BCA ASSESSMENT REPORT

**PROJECT: TNT TRANSPORT TERMINAL
ADDRESS: LENORE LANE, ERSKINE PARK**

Date: 27 August 2013

A NORTH ELEVATION
200 Scale 1:1000

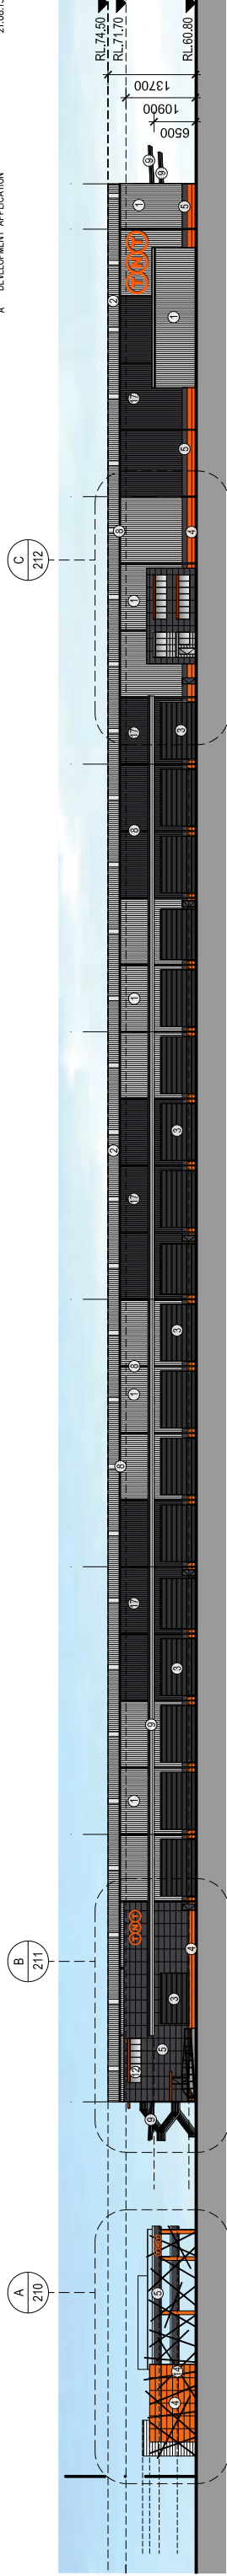
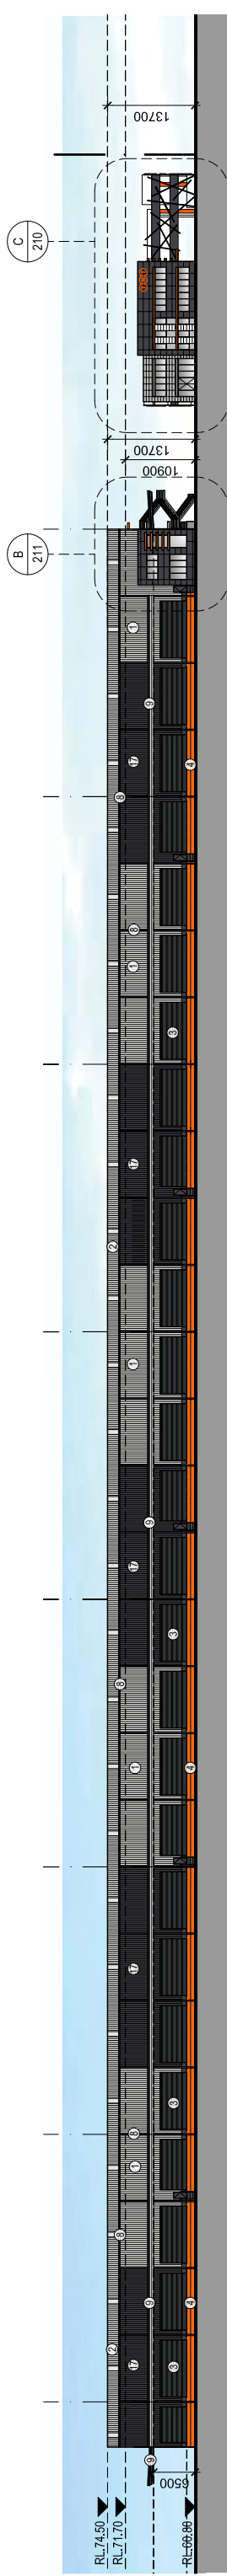
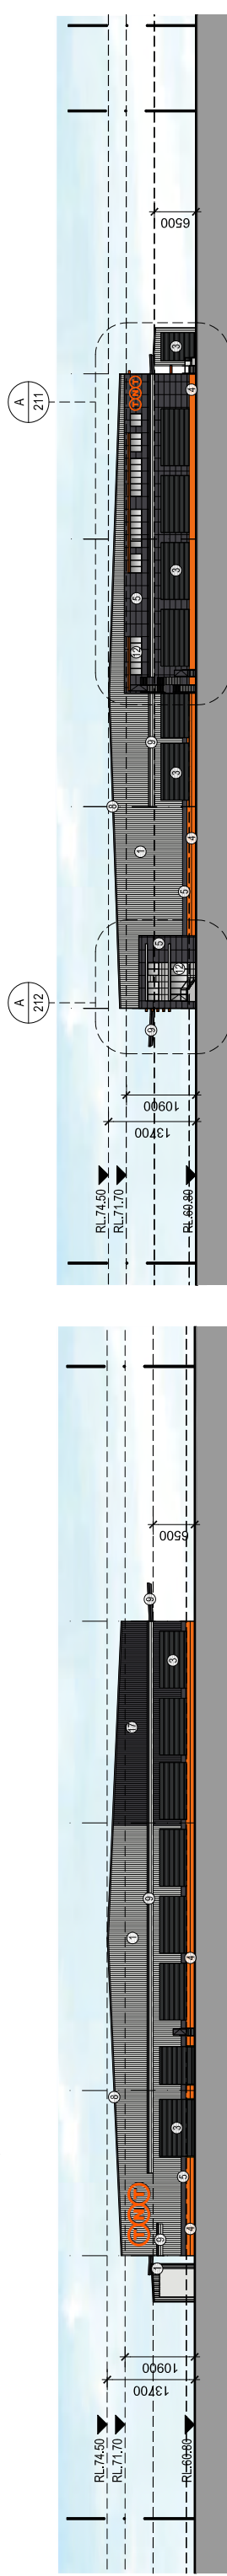
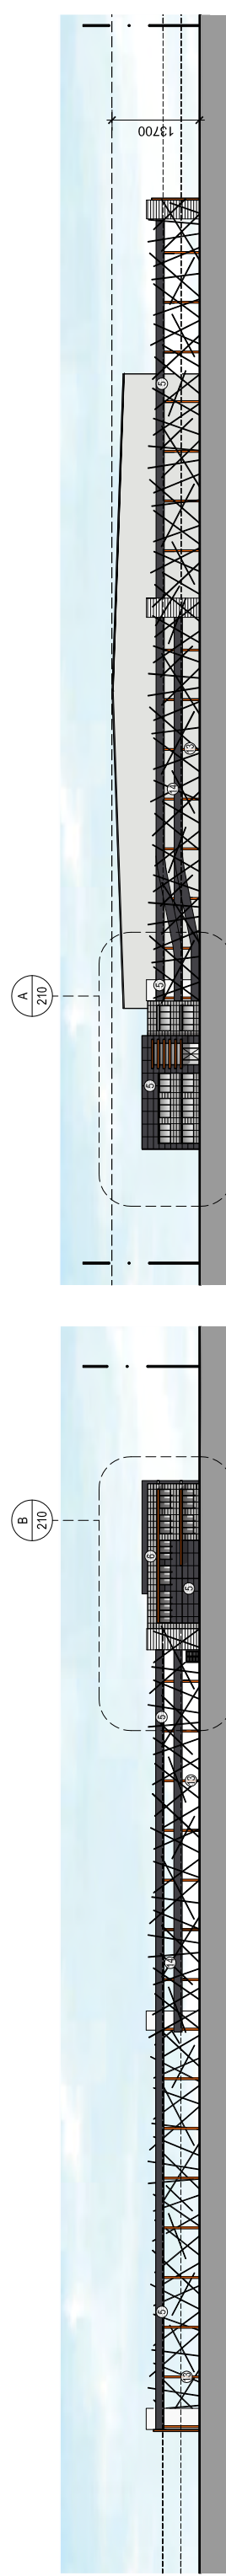
Comments: Main Office: Rise of 2 Storeys – the rooftop carpark is open to the sky and as such is not defined as a storey per C1.2. Warehouse: The area below the Main OPS Office measured from the platform level to the underside of the office slab exceeds 6m (6.25m per drawing no. 300/A. In accordance with C1.2(c) this area is deemed to be counted as two storeys, hence the overall rise in storeys of the warehouse building is three – see diagram below. The implication of this rise in storeys to the Warehouse Building is the need for Type B Construction to be applied – see notes under Spec. C1.1 below in relation to Type B Construction fire rating requirements applicable to the warehouse building.
